**RE: SSD 7462 – Minto Recycling Pty Ltd (Bingo Industries)  
No. 13 Pembury Road, Minto**

I refer to the Department's correspondence regarding the proposal to increase the permitted tonnage of waste per annum permitted to be handled at the subject site from its current 30,000 tonnes.

This response has been prepared following receipt of amended information from the proponent, which was prepared in response to submissions raised during the application's public exhibition.

**13 PEMBURY ROAD,
MINTO
LOT 1 DP 1013852**

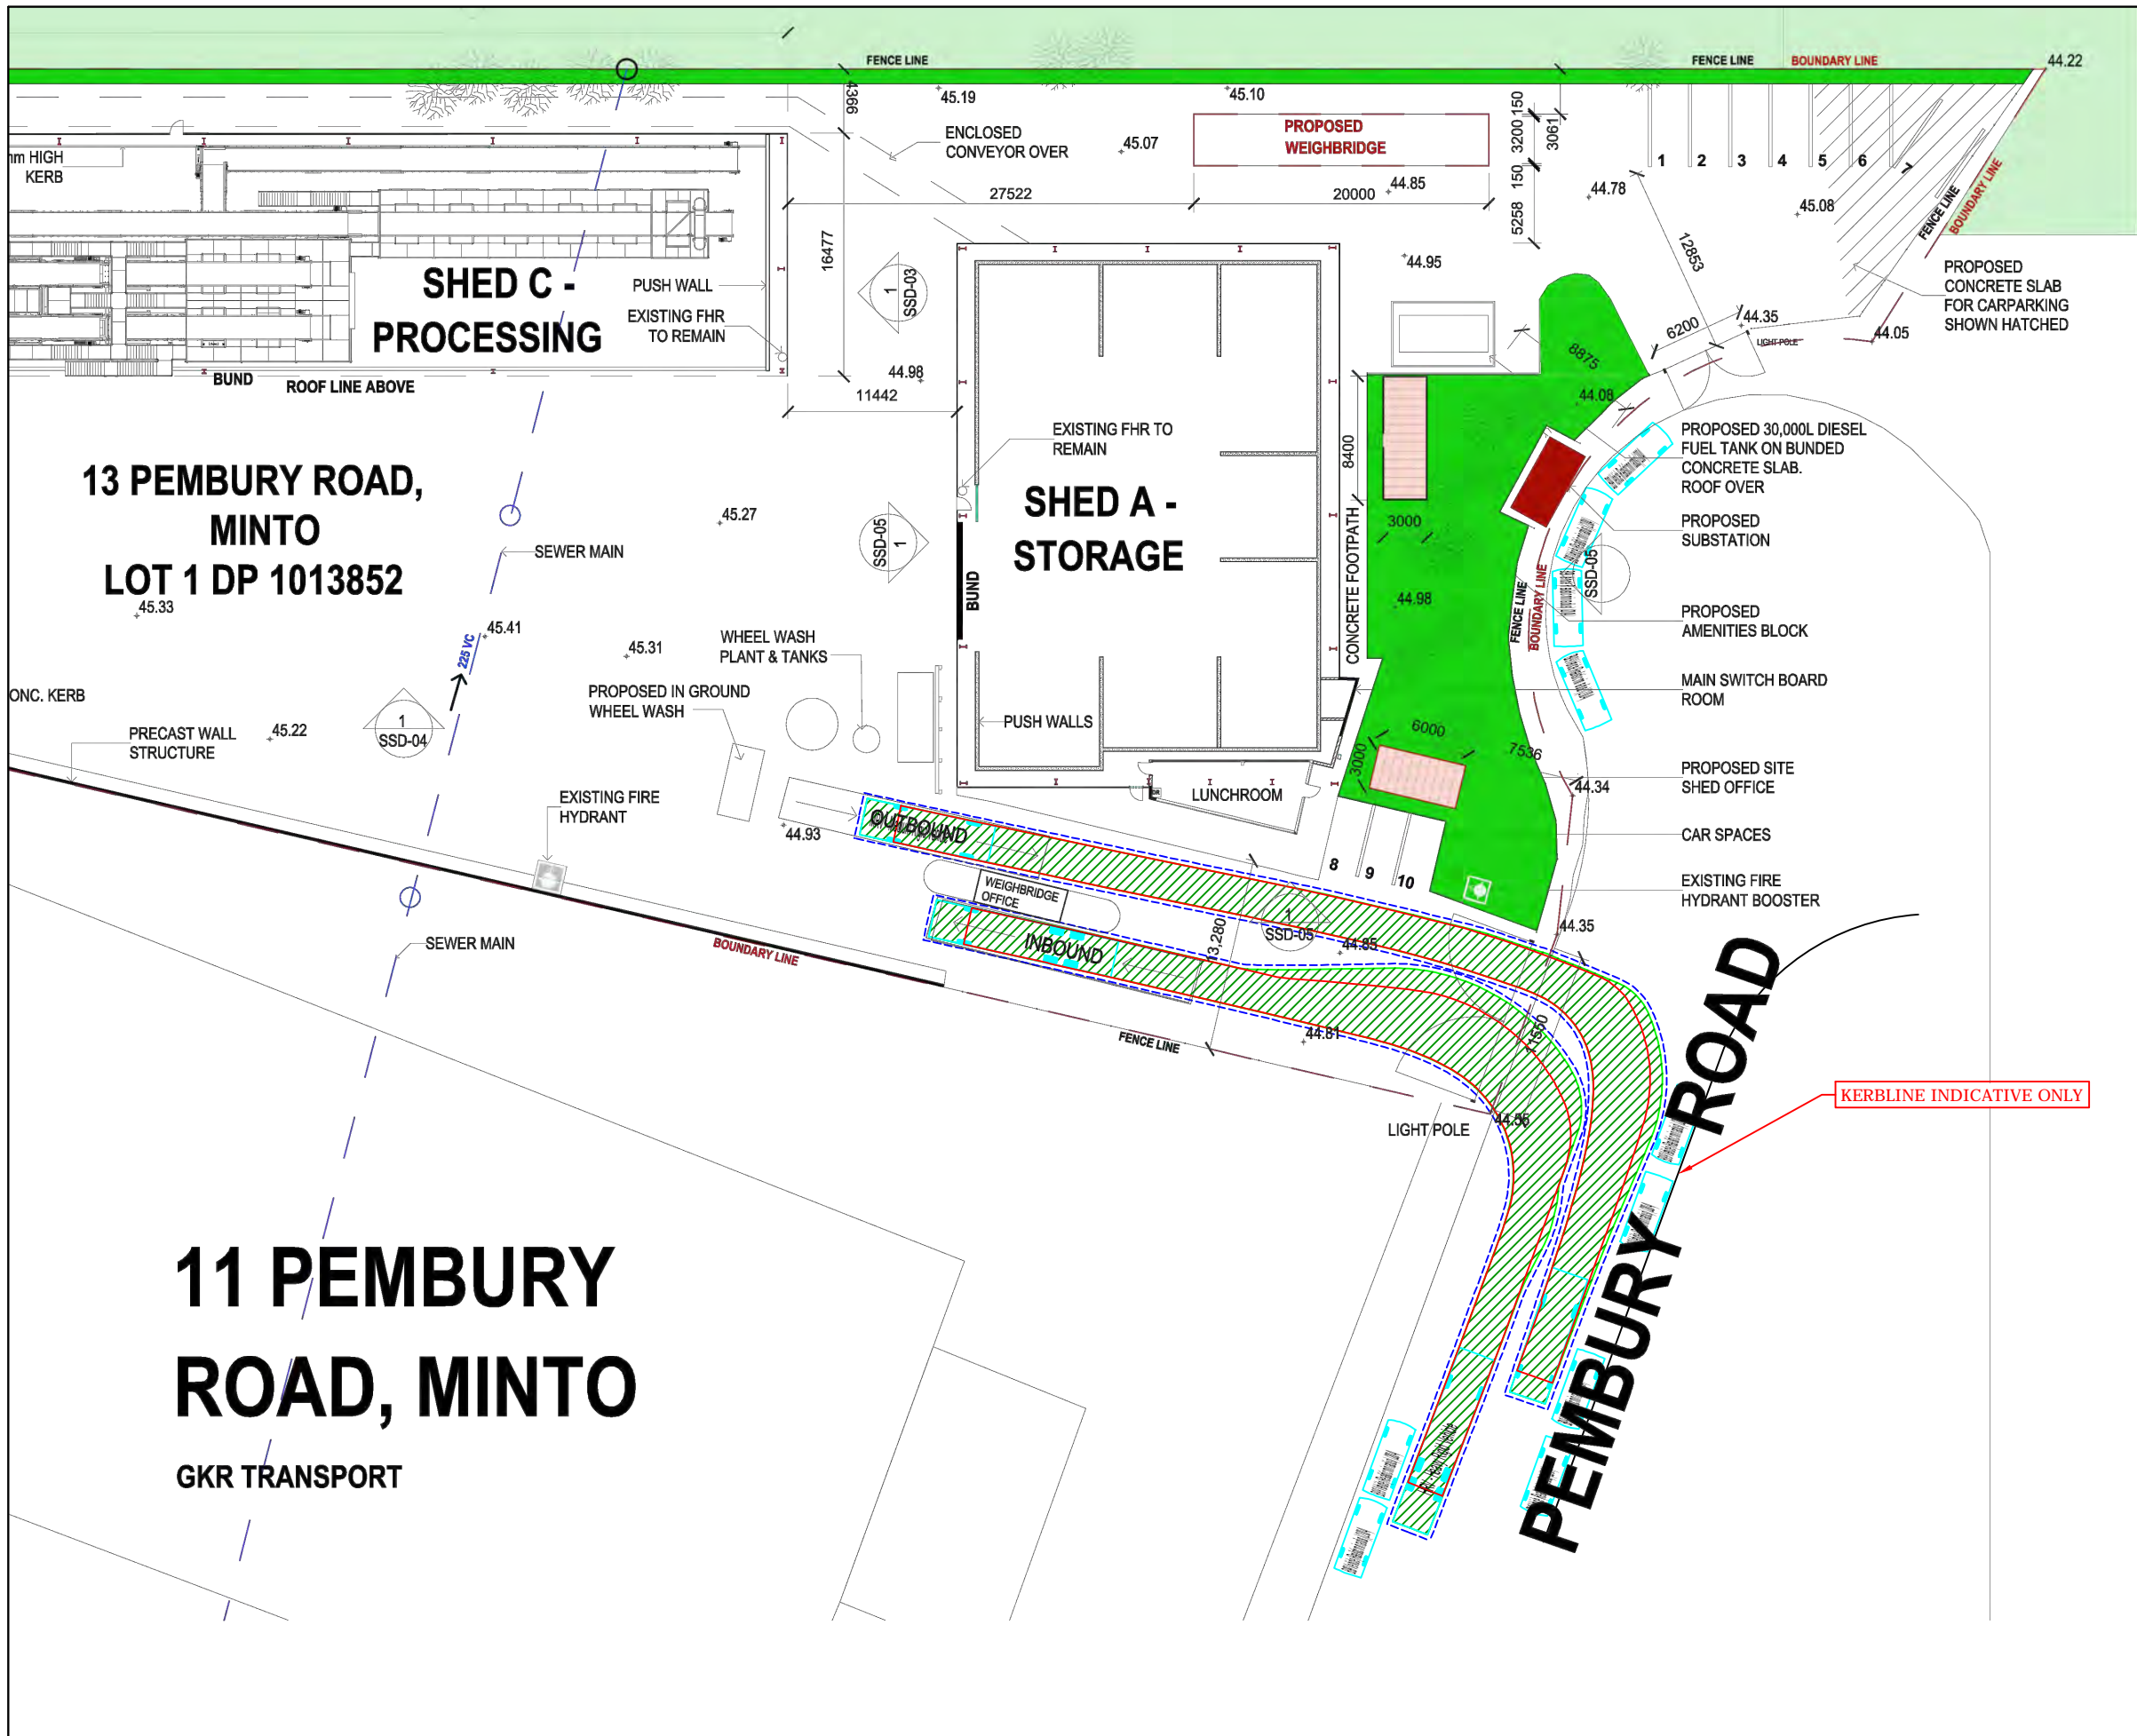
- The turning manoeuvres shown on submitted plans do not appear to be practical in some instances – with wheels crossing over weighbridge edges and the like, which is likely to damage the weighbridge and not be a permitted practice on site. The weighbridges are not generally flush with the surrounding pavement surface. Rather, they are likely to have a raised kerb or other raised element to ensure the vehicle is located appropriately.

- The stacking proposed within the building is not considered to be appropriate in terms of manoeuvring for articulated vehicles – there is no turning path shown that illustrates how an articulated vehicle would access the stack nearest the wall should the vehicle use entry weighbridge number 2. Manoeuvring within the building as proposed is reliant on articulated vehicles being in that particular stack.

- According to submitted turning paths, not all wheels of some articulated vehicles are located on the weighbridge after entering the site. Again, this is important as the weighbridges are not flush with the pavement surface. If vehicles cannot access the weighbridge in either a timely manner and importantly, an accurate manner, this raises issues with the monitoring of the site's performance in terms of its EPA licence restrictions and also the timeliness of the queuing/unloading criteria relied upon in the traffic assessment.

- No reverse to tip manoeuvre turning path is provided for b-double vehicles within the building. Are b-doubles broken down on site in order to perform their tipping manoeuvre? If not, how is the a-trailer emptied? Breaking down of the combinations would add time and influence queuing.
